Application Ref:	3/2020/1103	 <b>Ribble Valley Borough Council</b> <a href="http://www.ribblevalley.gov.uk">www.ribblevalley.gov.uk</a>
Date Inspected:	16.10.20 (pre app)	
Officer:	LE	
DELEGATED ITEM FILE REPORT:		Decision <b>APPROVE</b>

Development Description:	Proposed replacement dwelling.
Site Address/Location:	Overdale York Lane Langho BB6 8DT
CONSULTATIONS:	Parish/Town Council
No response at time of writing

**Sun Path Analysis**  
**May**  
**Existing**  
53.798872N -2.442115W

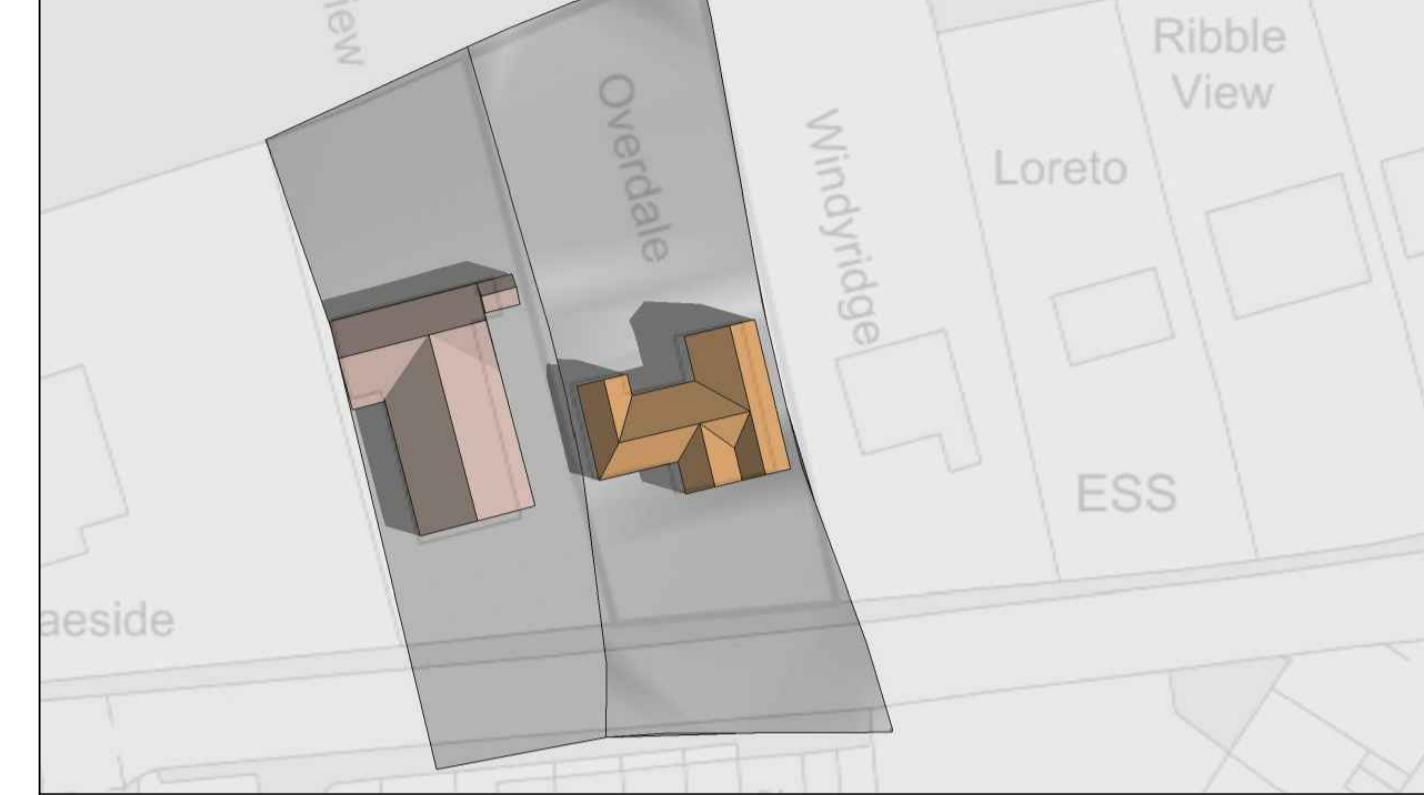
Petre View has side facing windows looking directly onto the site. The new dwelling be set behind these windows so it will not be overbearing. Windy Ridge is set at a slightly higher level and there is vegetation and a garage in-between the two properties which provides some screening. The sun path analysis submitted demonstrates that the new building will not overshadow the neighbours to a greater degree than the existing situation. There are no upper floor windows that would directly overlook other properties as the side facing ones are designed with a high sill level.

Proposed South Elevation

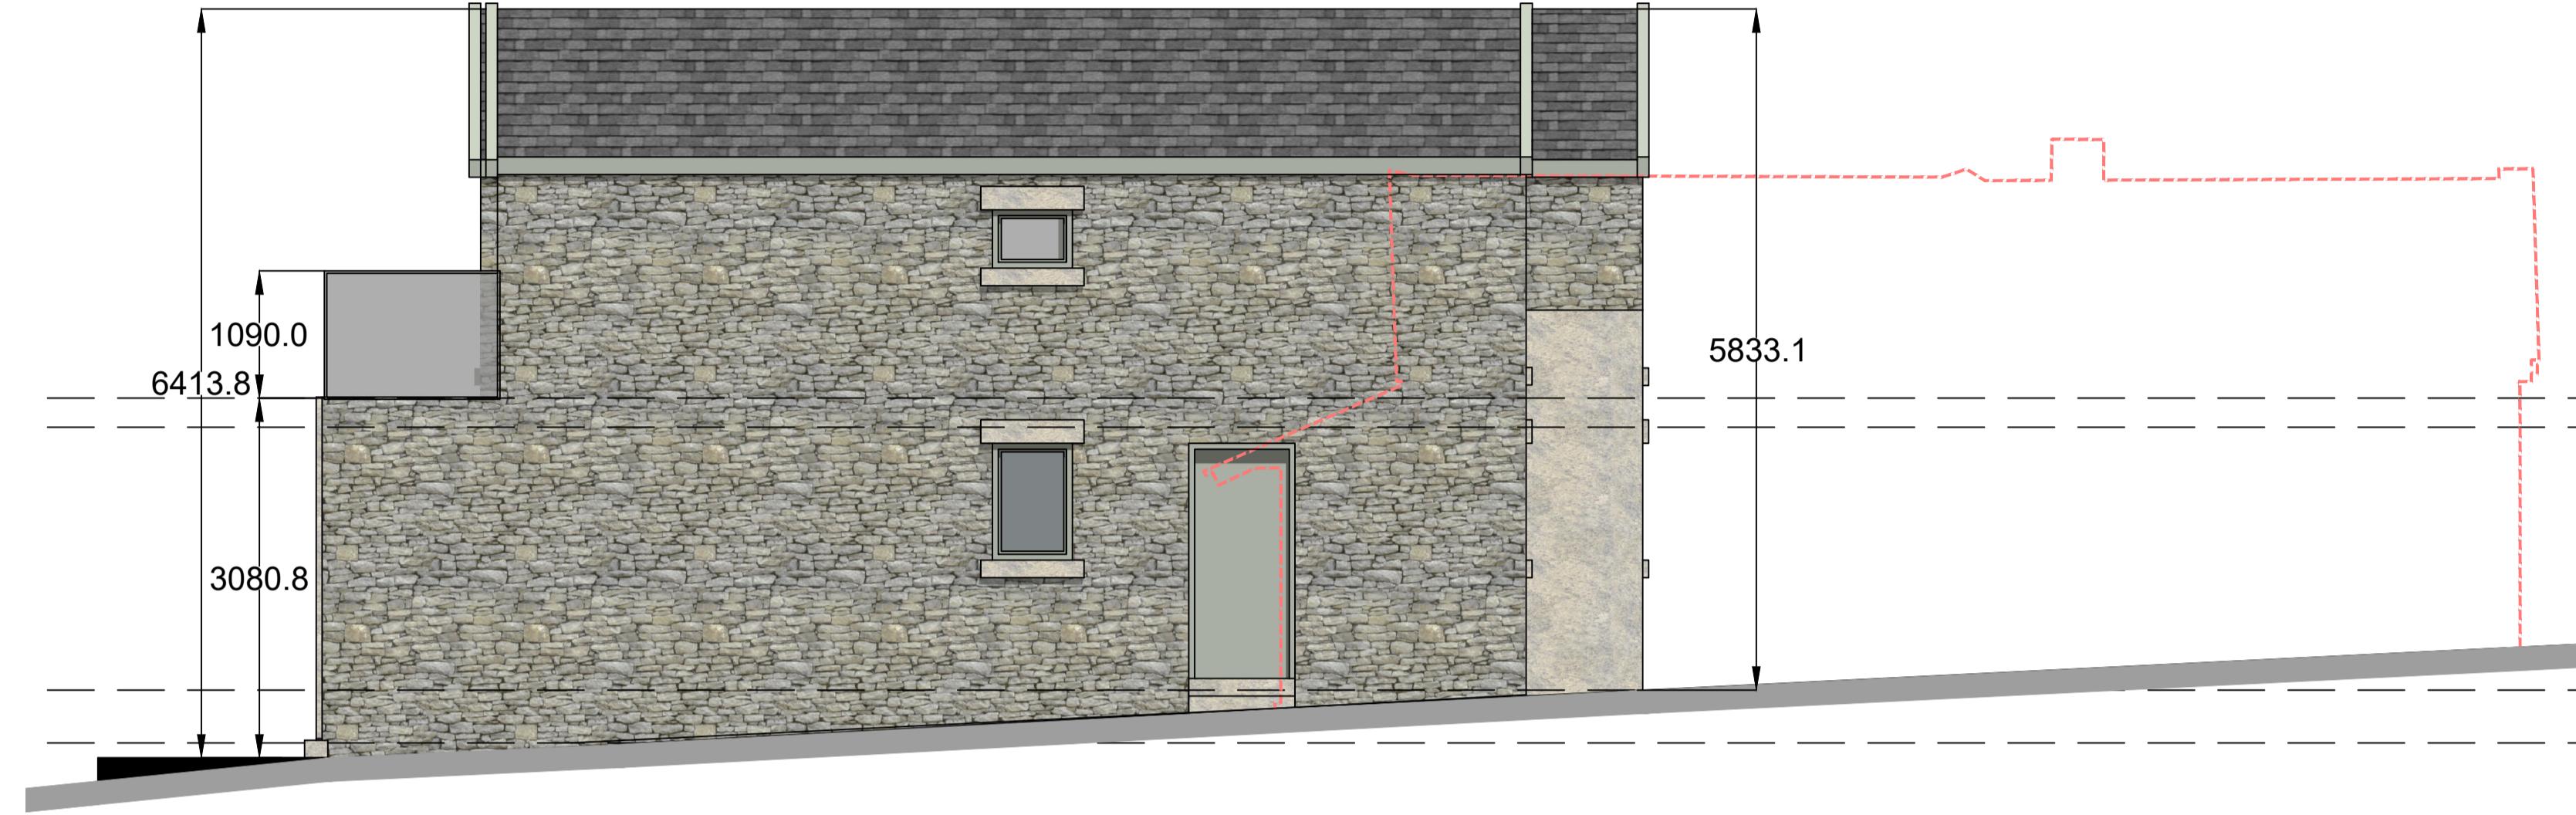
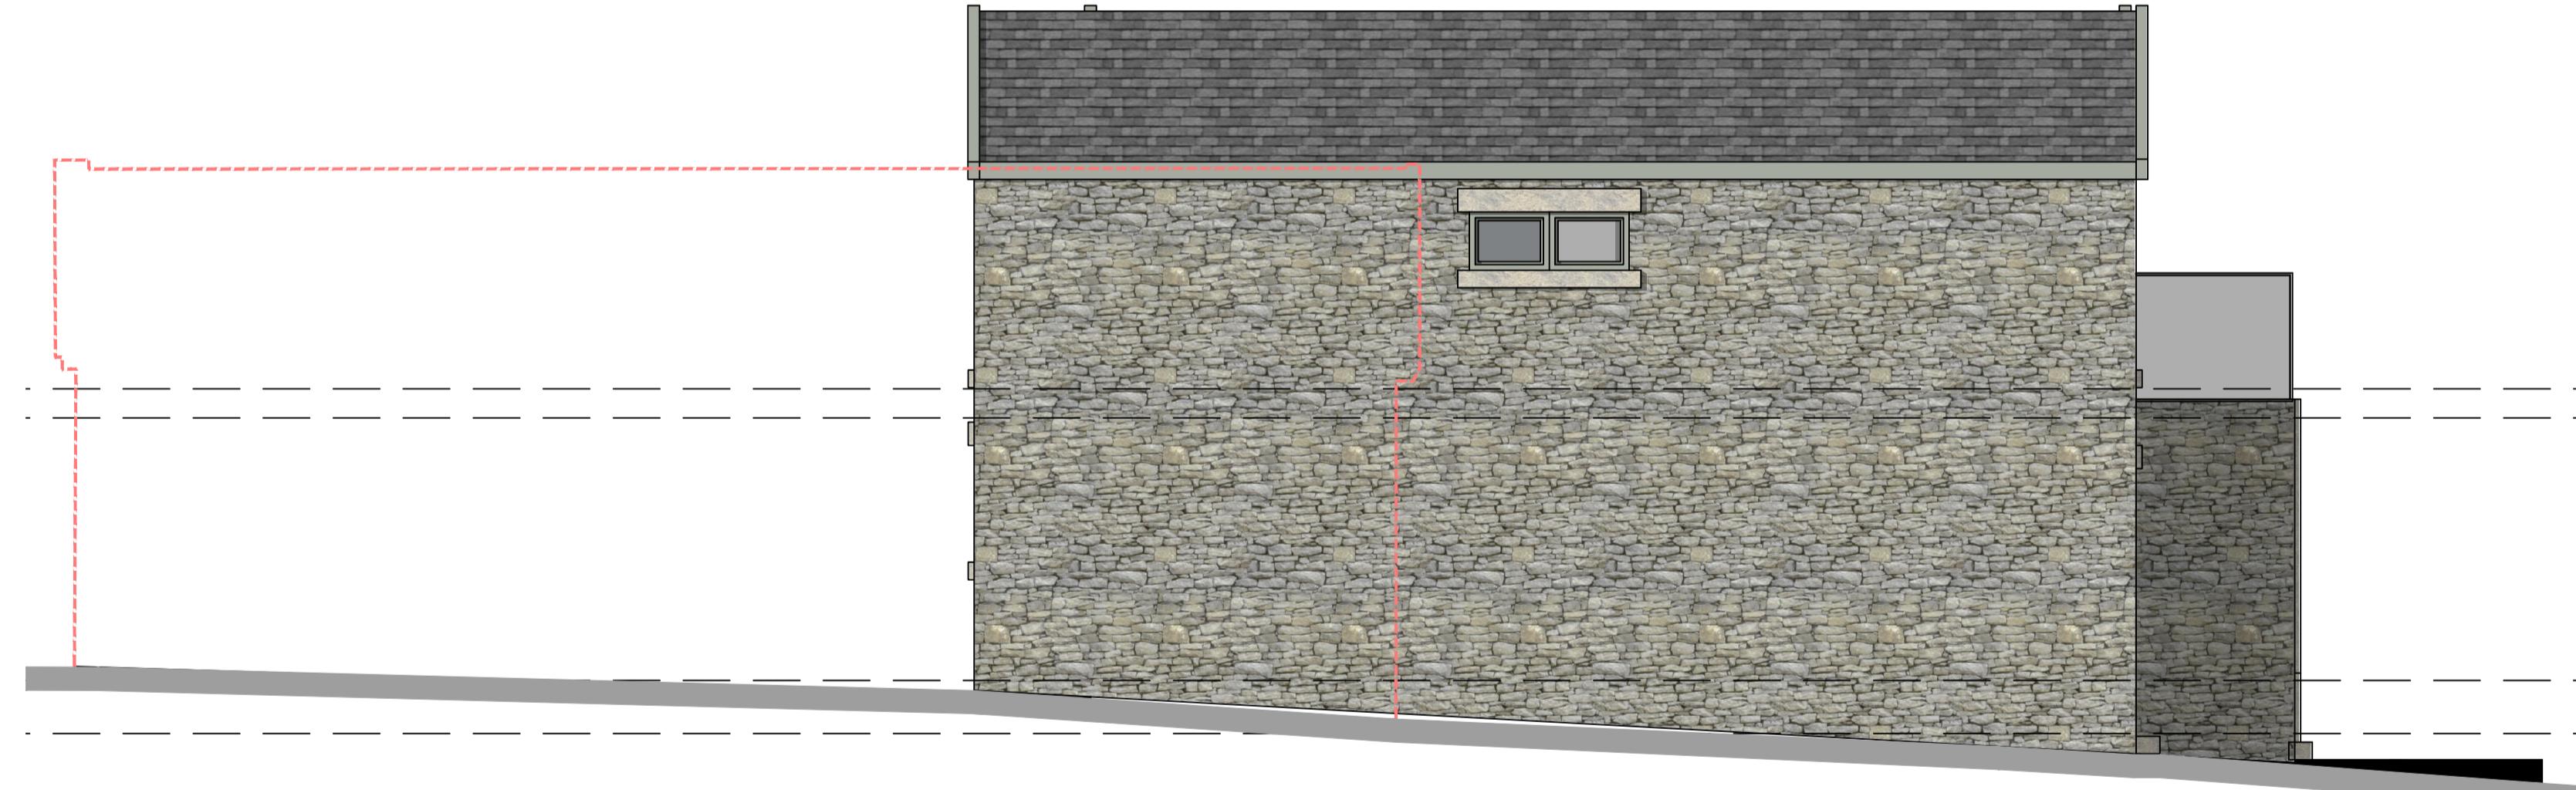
A balcony is proposed to the rear first floor elevation, with a glazed balustrade. This should be fitted with obscure glazing to the sides to protect the privacy of adjacent dwellings.

Site Section A

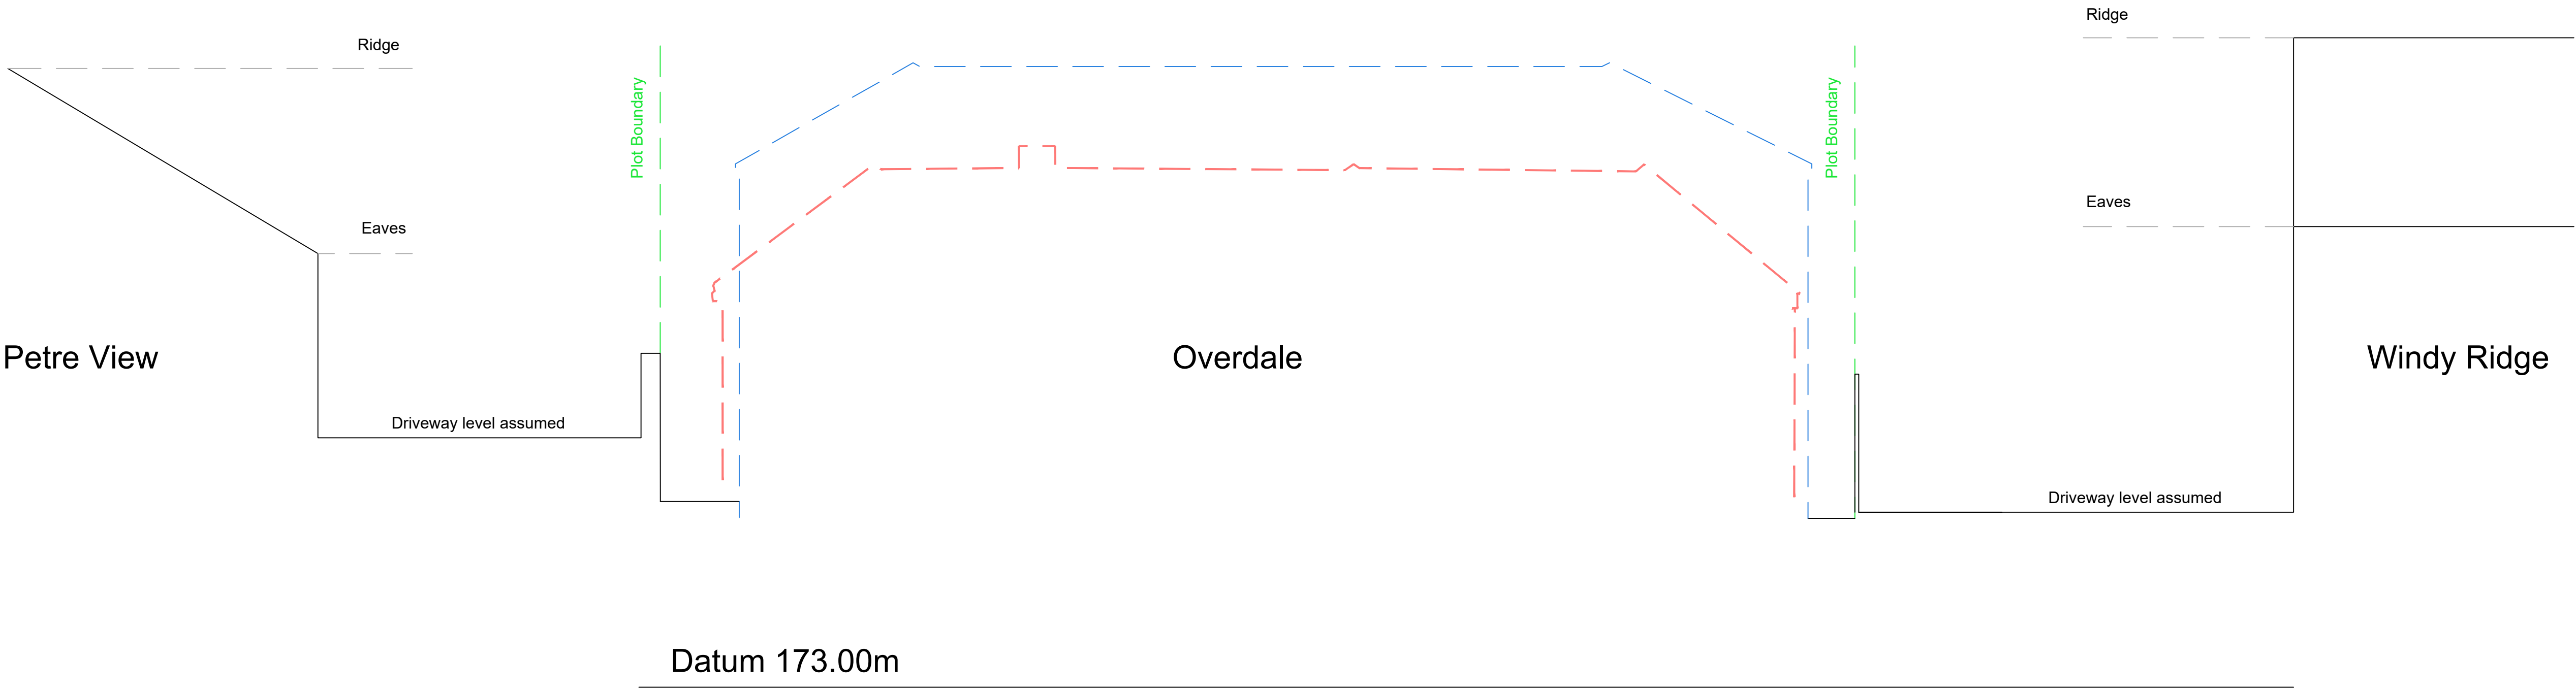
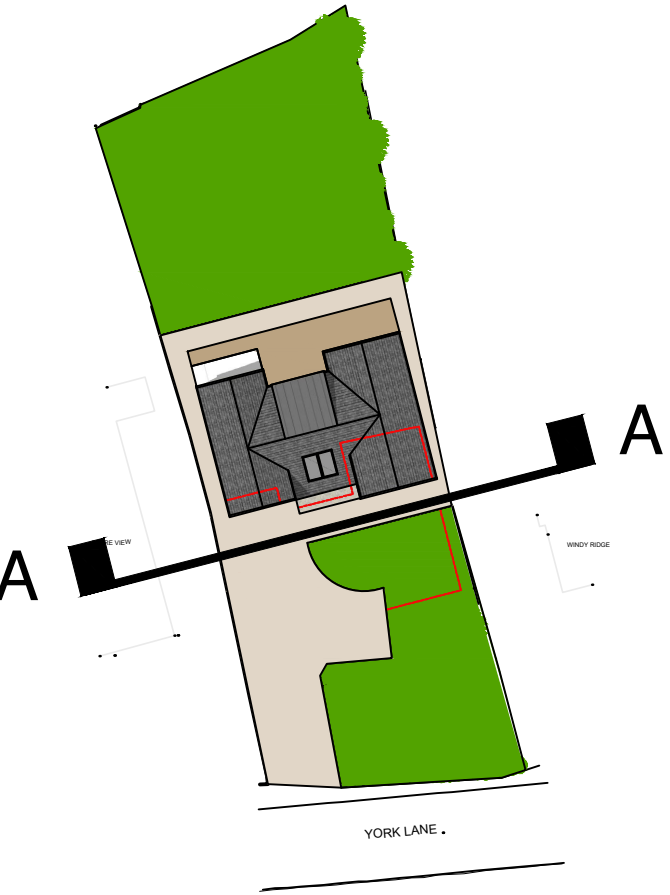
To the rear boundary of the garden are open fields which continue to slope down. In long distance views the dwelling will sit in between the two properties either side with the same gap to side boundaries as at present. The submitted site sections show that the new dwelling will be lower than Windy Ridge and the same height as Petre View at the ridge.
